EAST ANGLIA ONE NORTH

EAST ANGLIA TWO

Post-hearing submission

The case against open trenching of the River Hundred

- East Anglia ONE North and East Anglia TWO Onshore Development Area
- Work No 19
- Survey Area
- Target Note

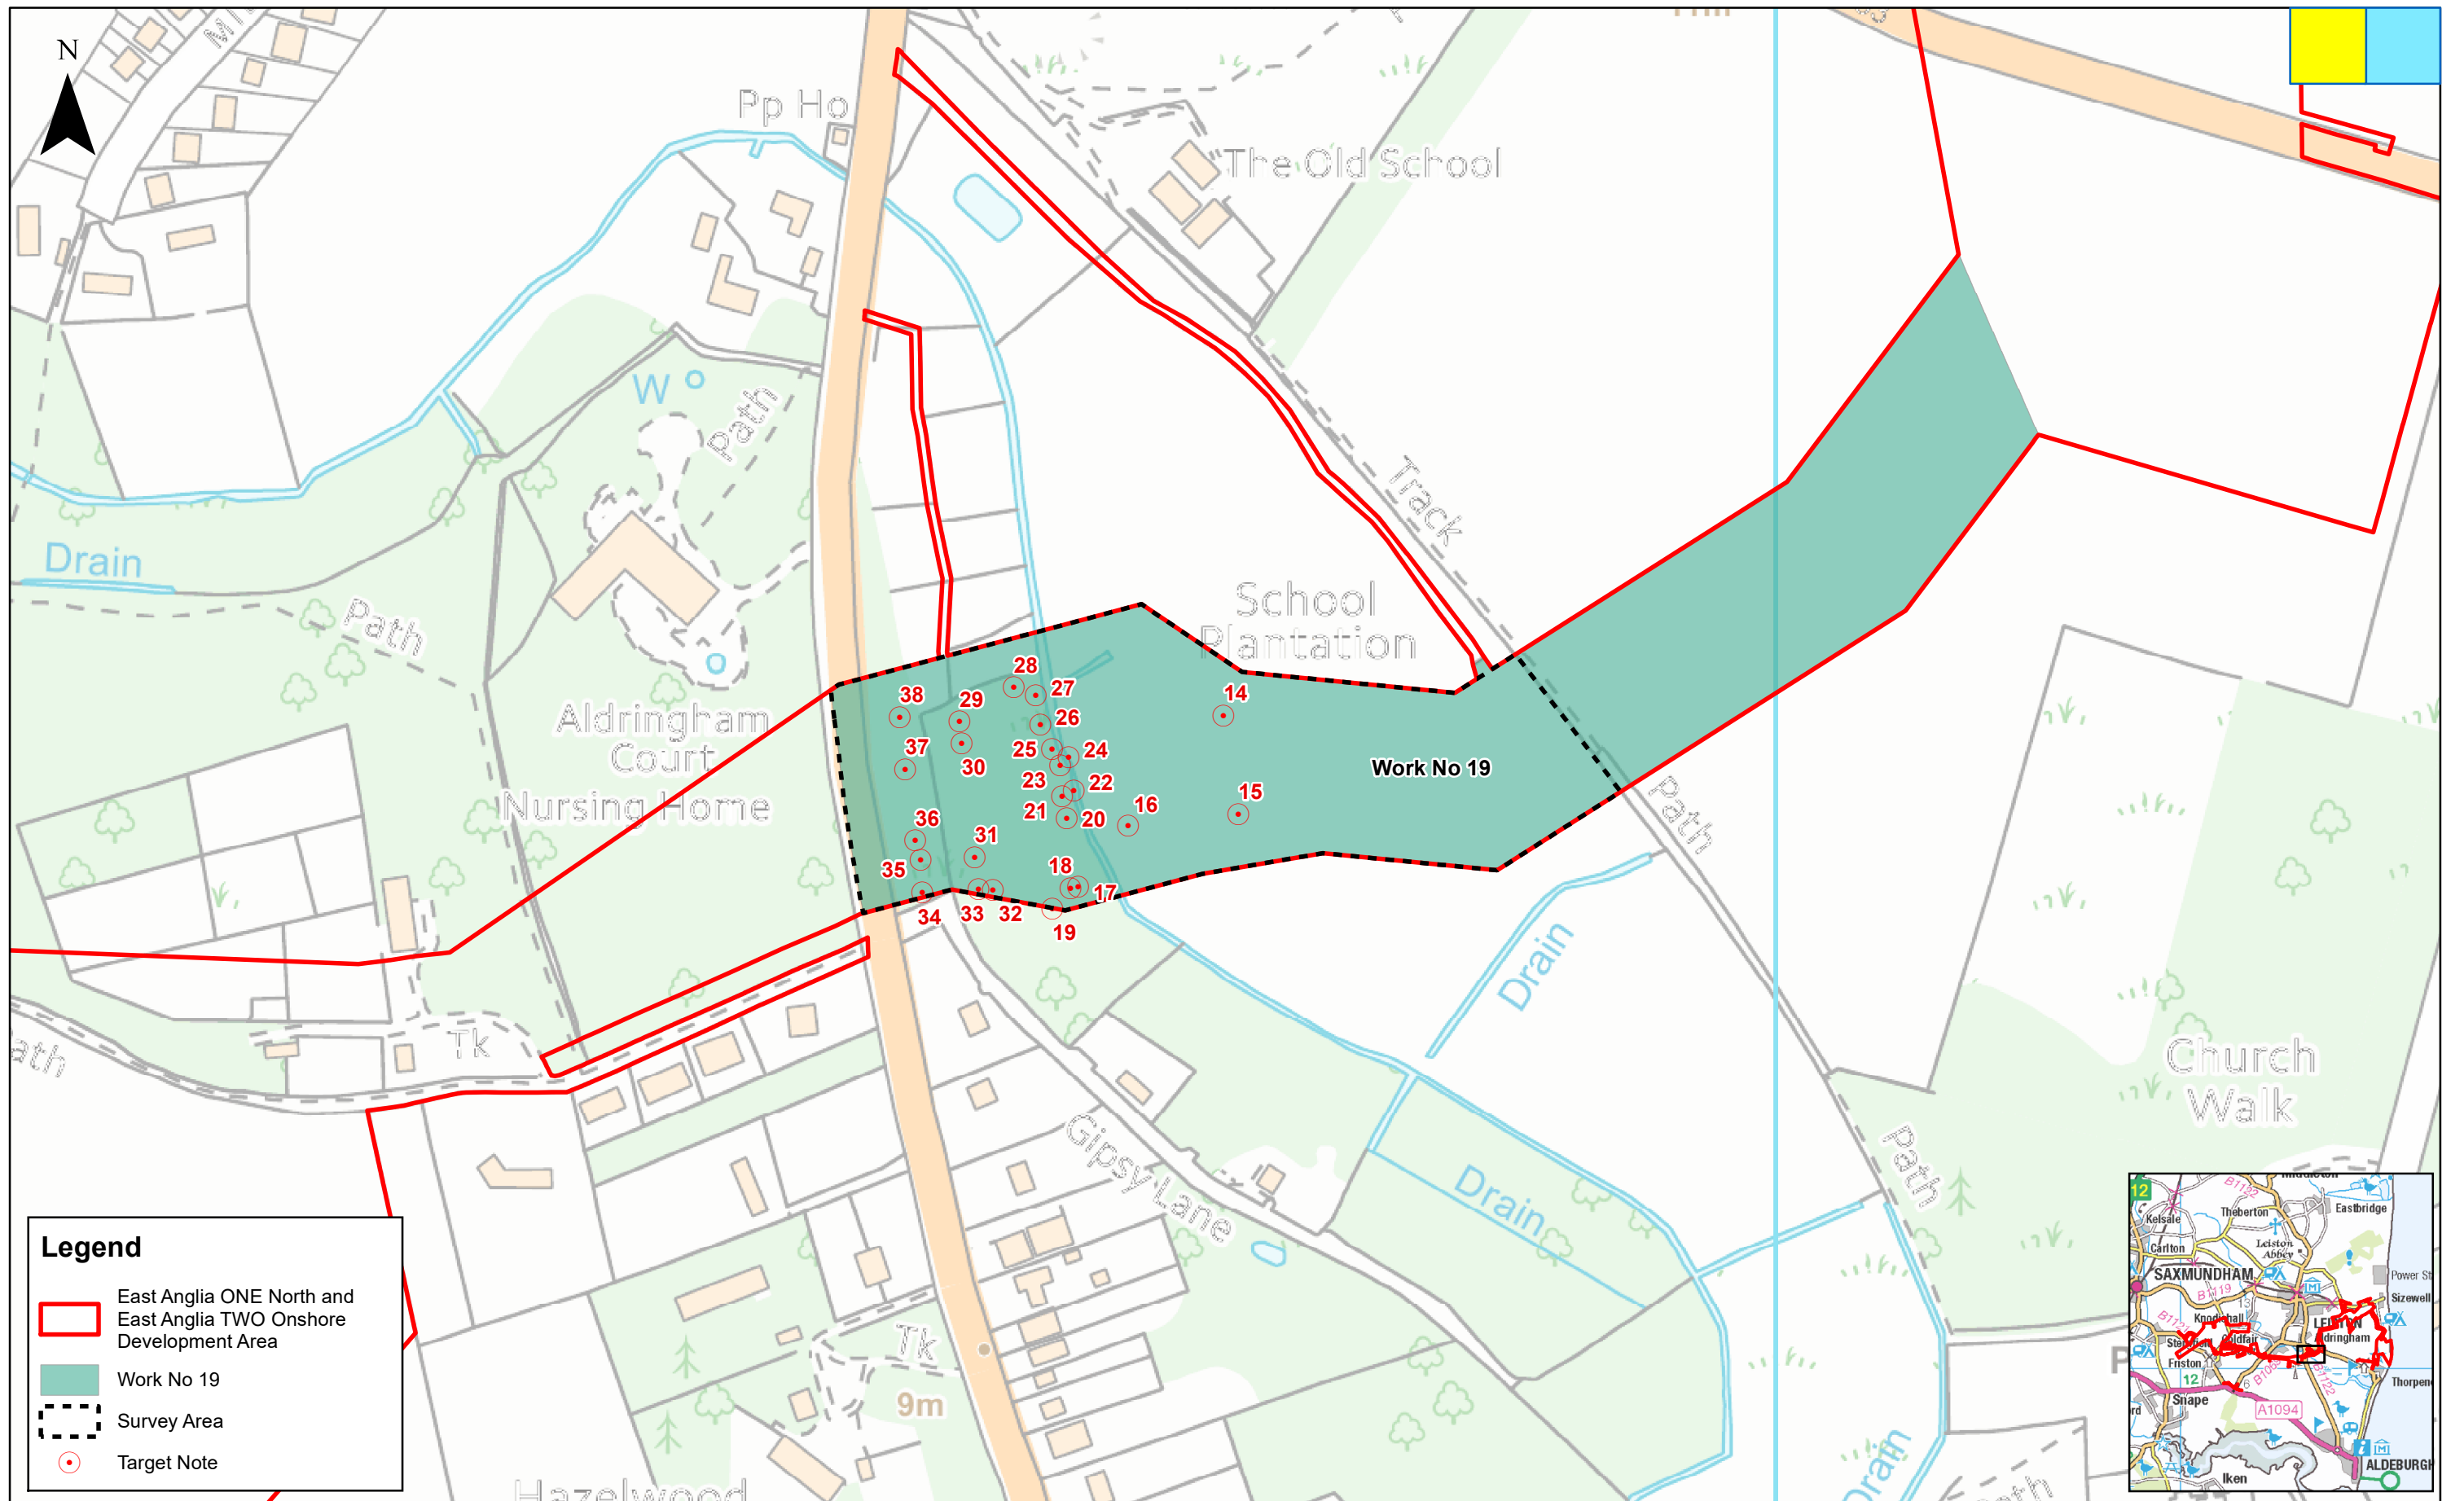
3.3 The River Hundred passes through a protected riparian woodland which may also be wet, most likely in the NVC W6 category. Again, a proper survey of this woodland by the Applicant has not been carried out.

3.4 The Applicant has not proposed mitigation for the River, nor for the protected meadow on the east bank, nor for the riparian woodland. A marginally narrower pair of trenches is not acceptable mitigation for the sacrifice of the river, meadow and woodland (currently, according to verbal presentations at ISH 14, the trenching is 2 x 34 = 68m, but wider at the river).

4.0 Open trenching is an unacceptable solution as it will permanently destroy, without mitigation, vital habitats and resources, on both sides of, and including, the River, which are protected. There can be no biodiversity net gain here.
